M5 Junction 10 Improvements Scheme

Additional information relating to
Examining Authority's Question Q.1.0.14

TR010063 - APP 9.62

Additional information in relation to Examining Authority's Question Q1.0.14

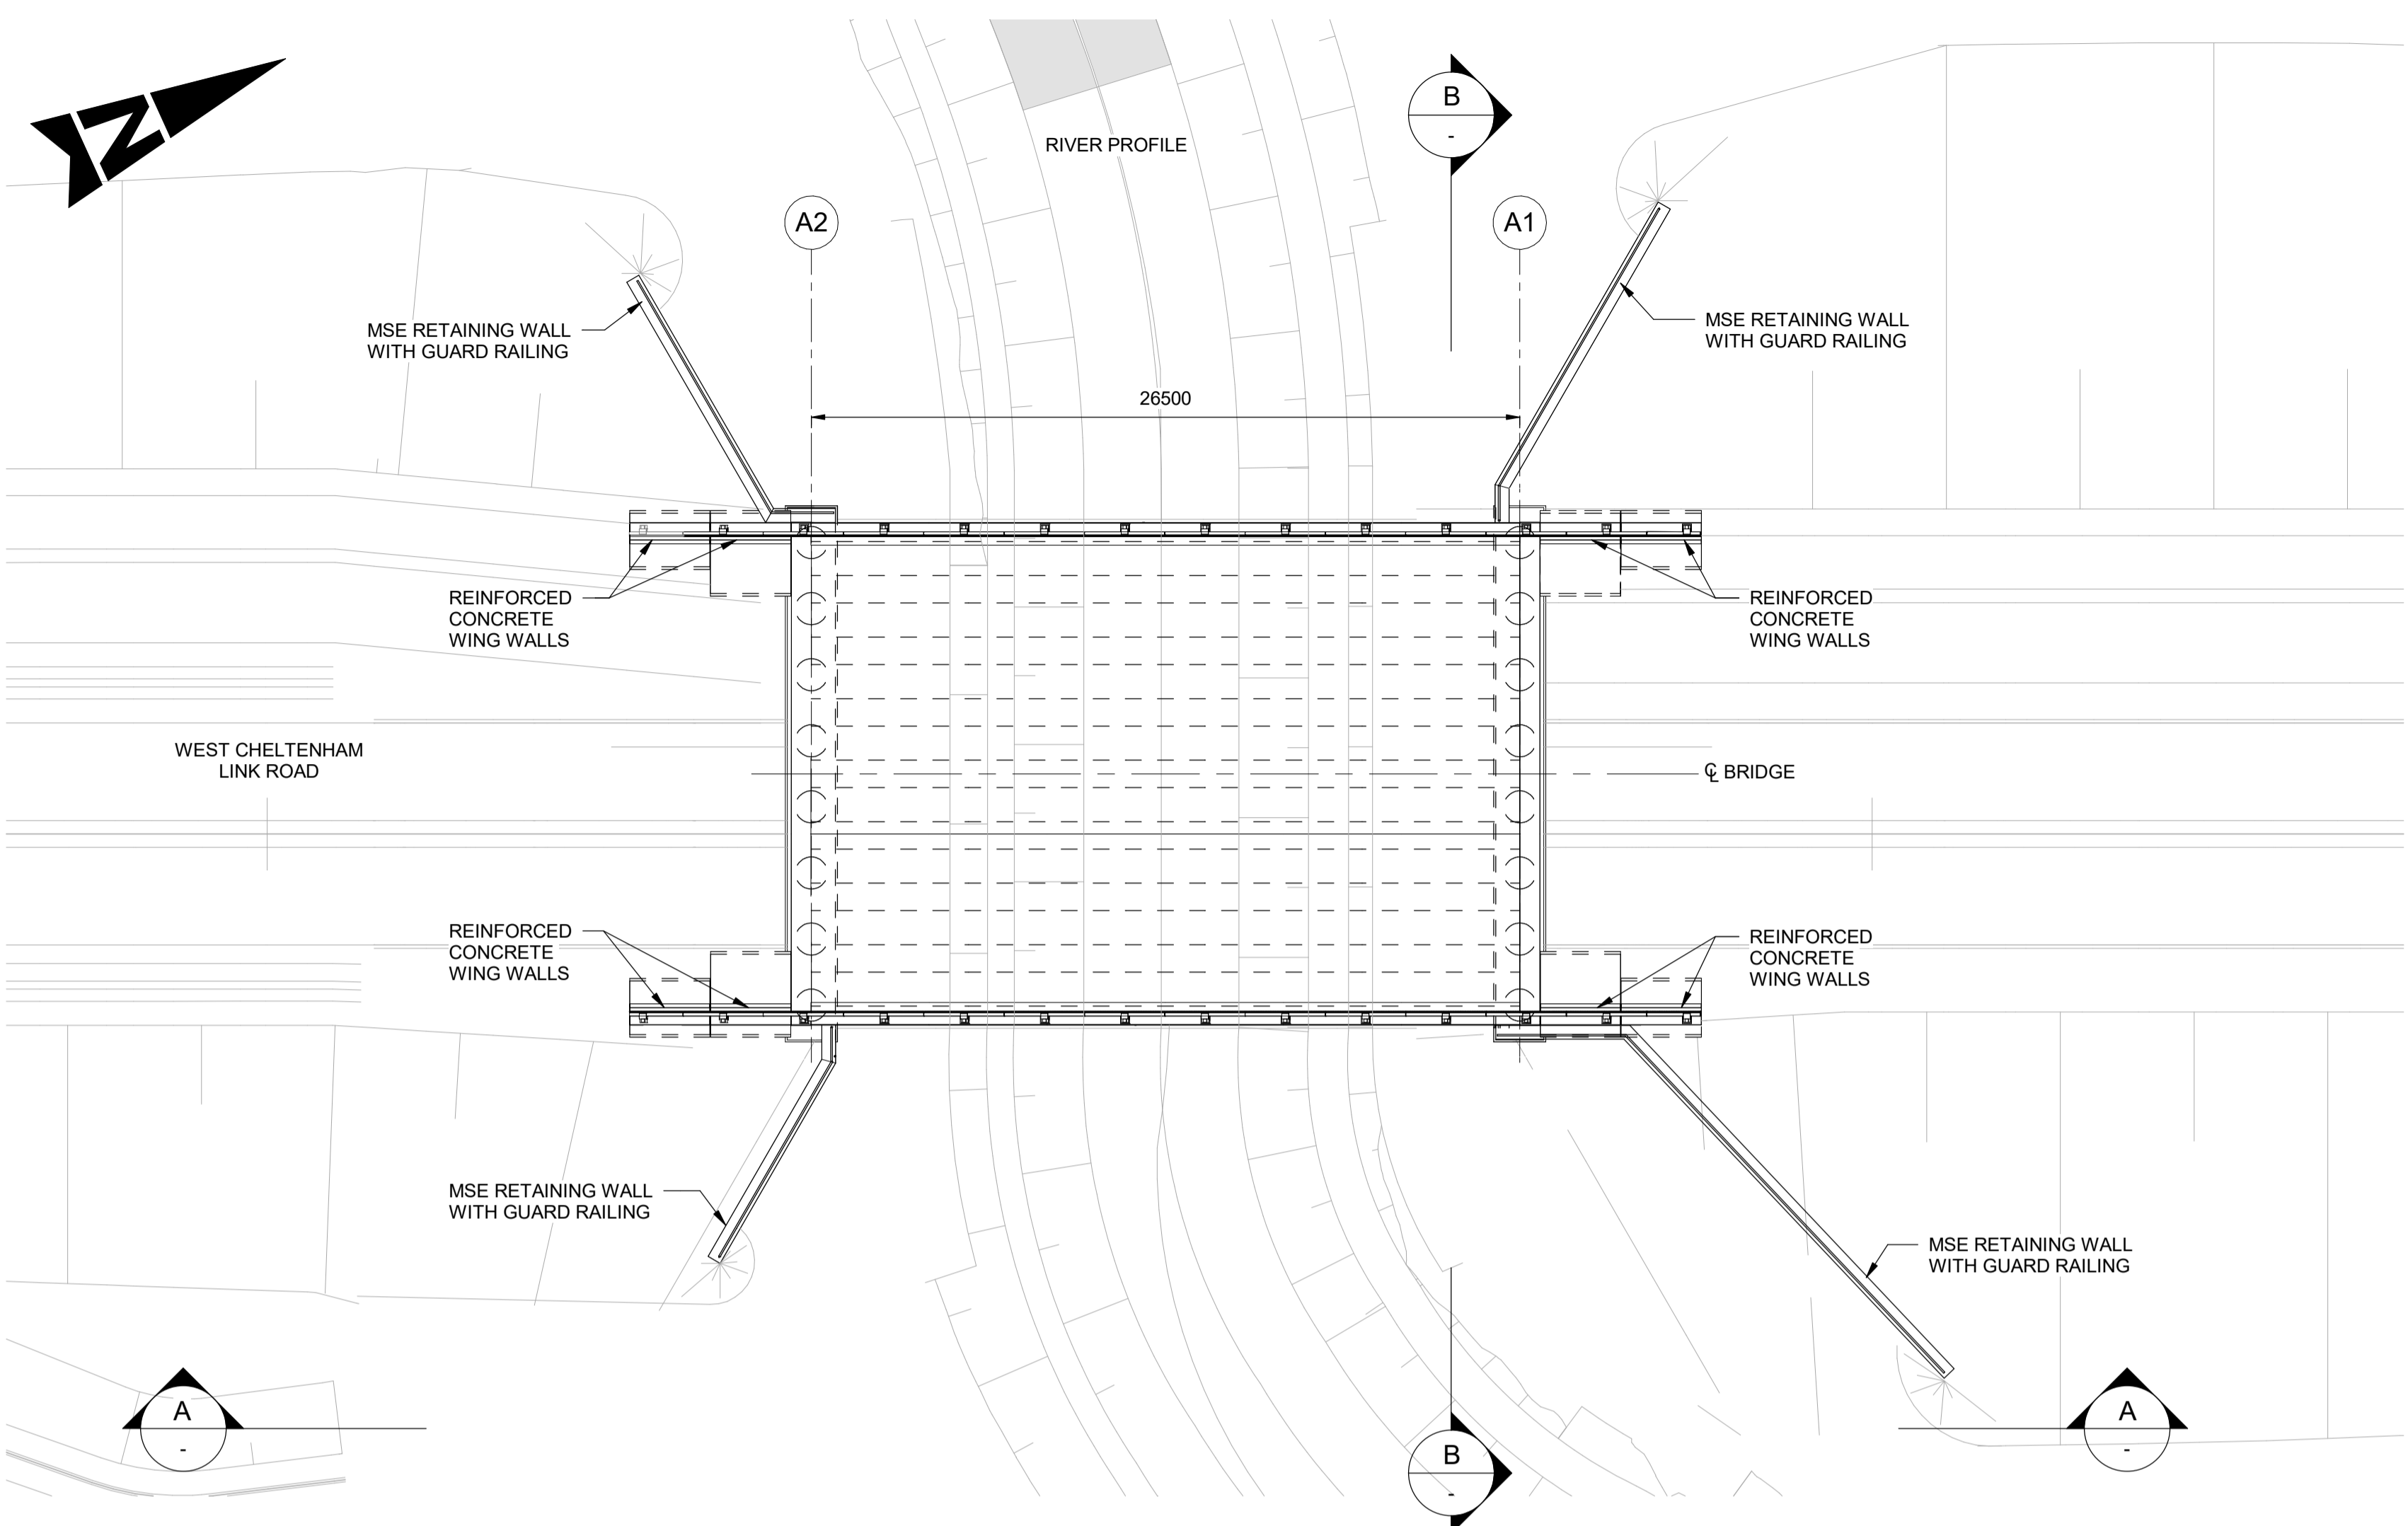
Topic / document	National Highways Comments in RR-026 Appendix B	Applicant Response
<p>Transport Assessment Chapter 4 Paragraph 4.2.4</p>	<p>Transport Assessment Chapter 4 Paragraph 4.2.4 National Highways requires clarification of the location of farmland access track as referenced in 4.2.4 of the Transport Assessment and clarification of how this is accessible from the SRN.</p>	<p>General Arrangement Plans for the Scheme, that show the locations of access to farmland, have been submitted with the DCO application (APP-014 and APP-015).</p> <p>The access to farmland referred to in the scheme description of TA is the existing farm track that is currently accessed off the A4019 where the M5 southbound off-slip merges with the A4019 eastbound, which is an inherently unsafe location for an access. The Scheme amends this access so that it is incorporated into the signal-controlled junction of the A4019 with the West Cheltenham Link Road. See Sheet 12 of the General Arrangement Plans (APP-015).</p> <p>This matter is agreed 24/07/2024.</p>
